Appeal Decision

Appeal Ref: APP/R5510/D/21/3278863

17 Boniface Road, Ickenham UB10 8BU

- The appeal is made under section 78 of the Town and Country Planning Act 1990 against a refusal to grant planning permission.
 - The appeal is made by Ms A Nathwani against the decision of the London Borough of Hillingdon.
 - The application Ref 12629/APP/2021/1144, dated 22 March 2021, was refused by notice dated 12 May 2021.
 - The development proposed is a first-floor side extension.
-

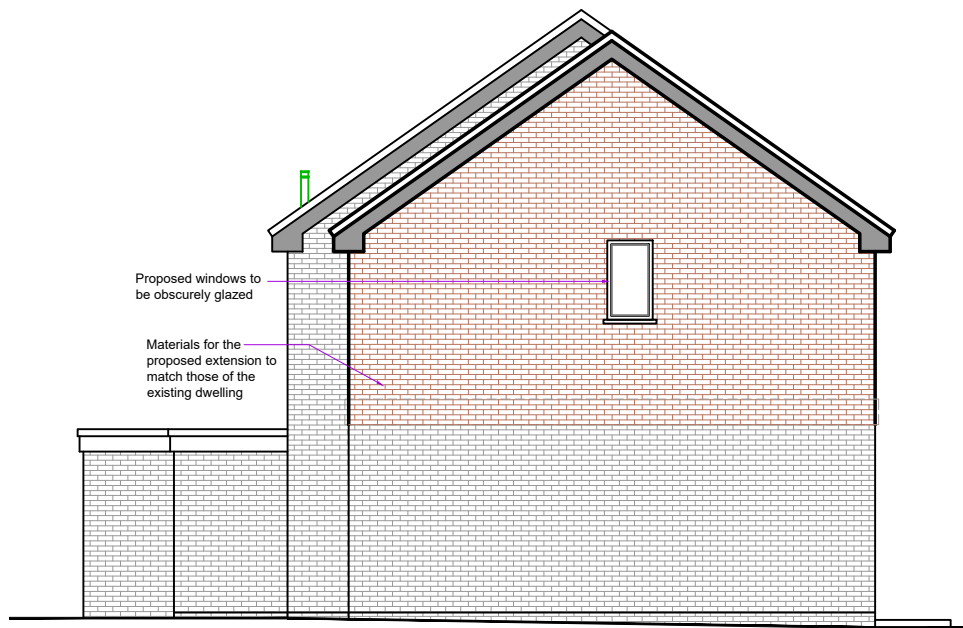
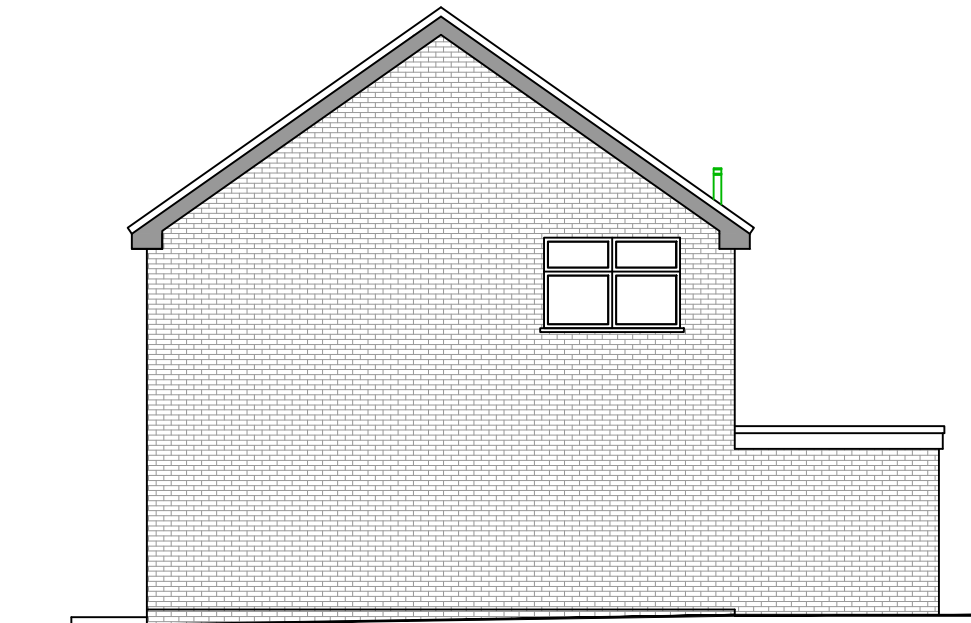
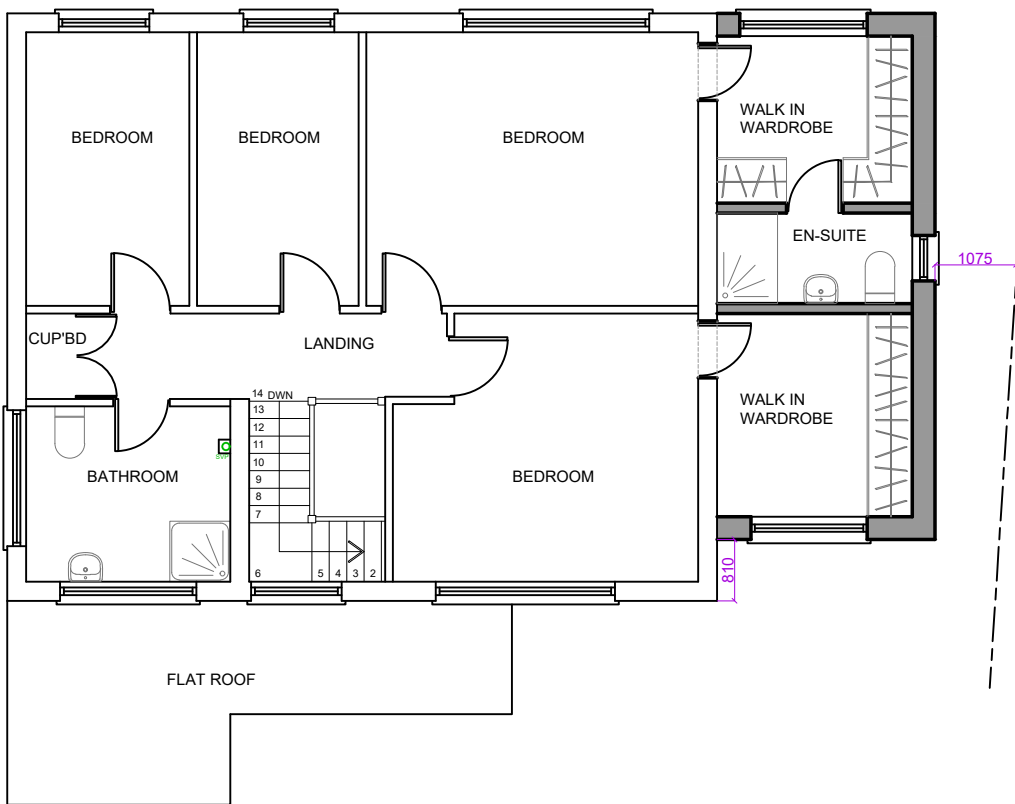
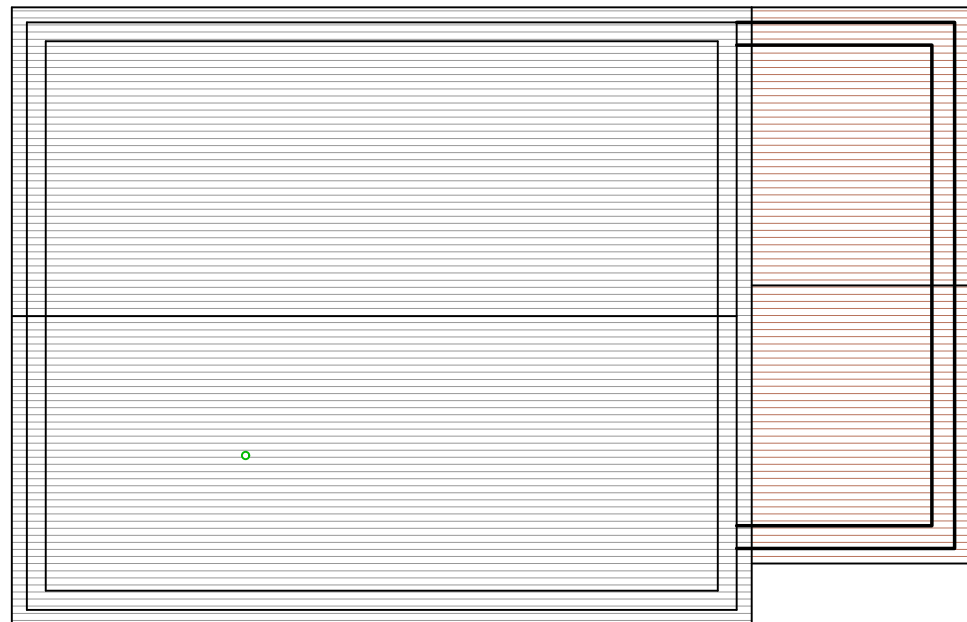
5. The site is a corner plot house in a residential area. It adjoins The Mallows, a short cul-de-sac which accommodates a number of dwellings on its eastern side, as well as further dwellings to the west behind 17 Boniface Road. No 17 is a detached property with a ground-floor element on one side. This element is situated close to the fenced boundary of the site which immediately adjoins the pavement along The Mallows. The existing form of the building promotes a feeling of openness through to The Mallows from Boniface Road.
6. The first-floor side extension would develop the space above the existing ground-floor element. It would have a lower ridge height than the main

dwelling and extend to the full width of the existing ground-floor element. Due to the site's proximity to the Mallows, its corner position, and the width of the extension, the development would reduce the existing sense of openness, and confine the approach to The Mallows. It would be prominent and imposing and result in harm to the character and appearance of the area.
